From: Nigel Jenkins [REDACTED]
Sent: 03 February 2014 18:25
To: Nat Slade
Subject: 50m stack

It has been suggested to me that you may be able to assist in providing comments on a planning application ref: WSCC/096/13/F for a waste treatment facility at Ford, West Sussex. The application is submitted to and determined by West Sussex County Council, but Arun DC have been consulted. An EIA has been produced which addressed the impact on air quality. Would you be able to review the documents which are available on the County Council's website and provide comments? If possible it would be useful to have these by 15th January.

From: Nigel Jenkins [REDACTED]
Sent: 03 February 2014 18:14
To: Nat Slade
Subject: Air Quality Assessment comments for WSCC/096/13/F

Title
ELEVATIONS

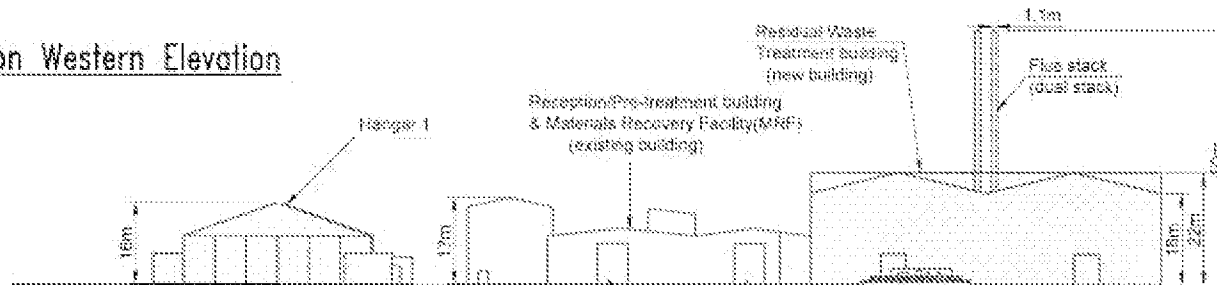
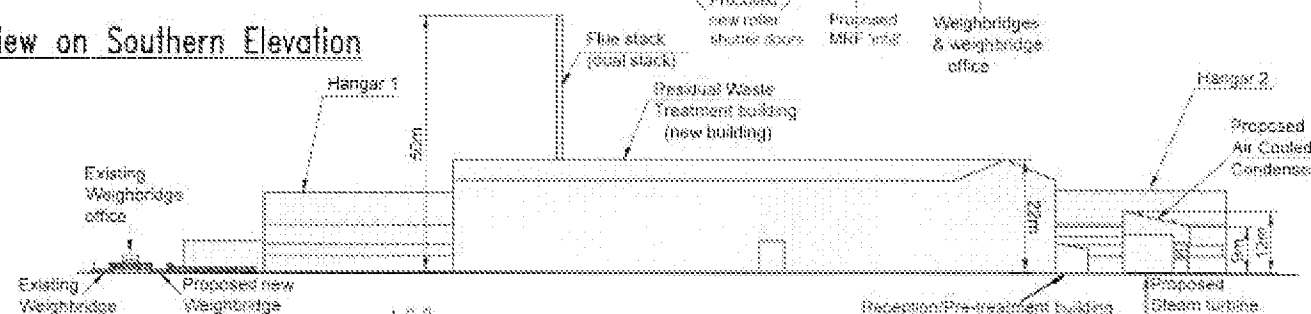
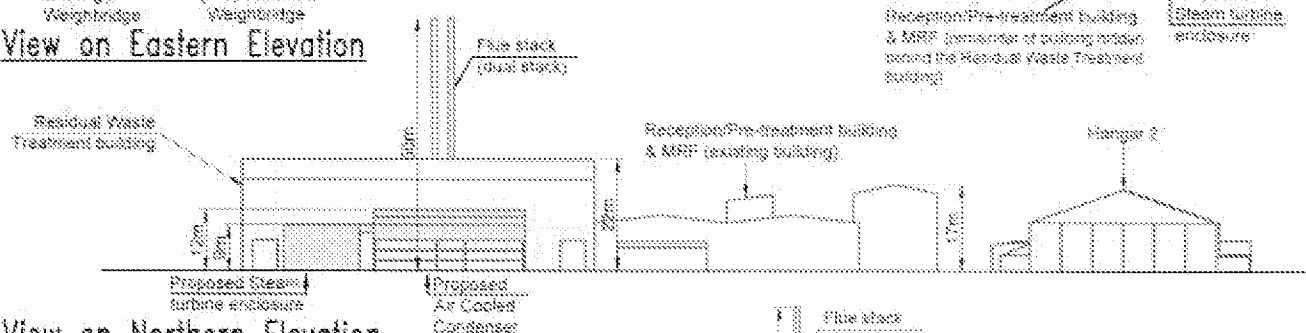
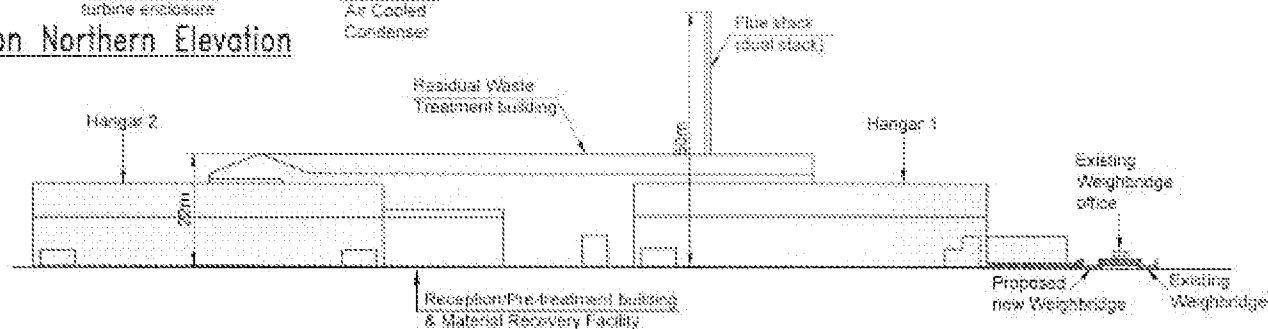
If there is a reduction in height to 45m

- Is it an urban environment, i.e. potential sensitive receptors, like schools, homes, hospital etc = concern if dispersion not maximised
- Is it in an area of concern i.e. an AQMA? = concern over cumulative effects
- Does the reduction decrease the viable dispersion of the stack i.e. what is the stack height calc say about this stack and emissions? = go by calc for best dispersion,

It may possible to reduce stack by increasing temp, exit velocity to compensate, or improve emission controls (scrubbing) = reduce emissions.
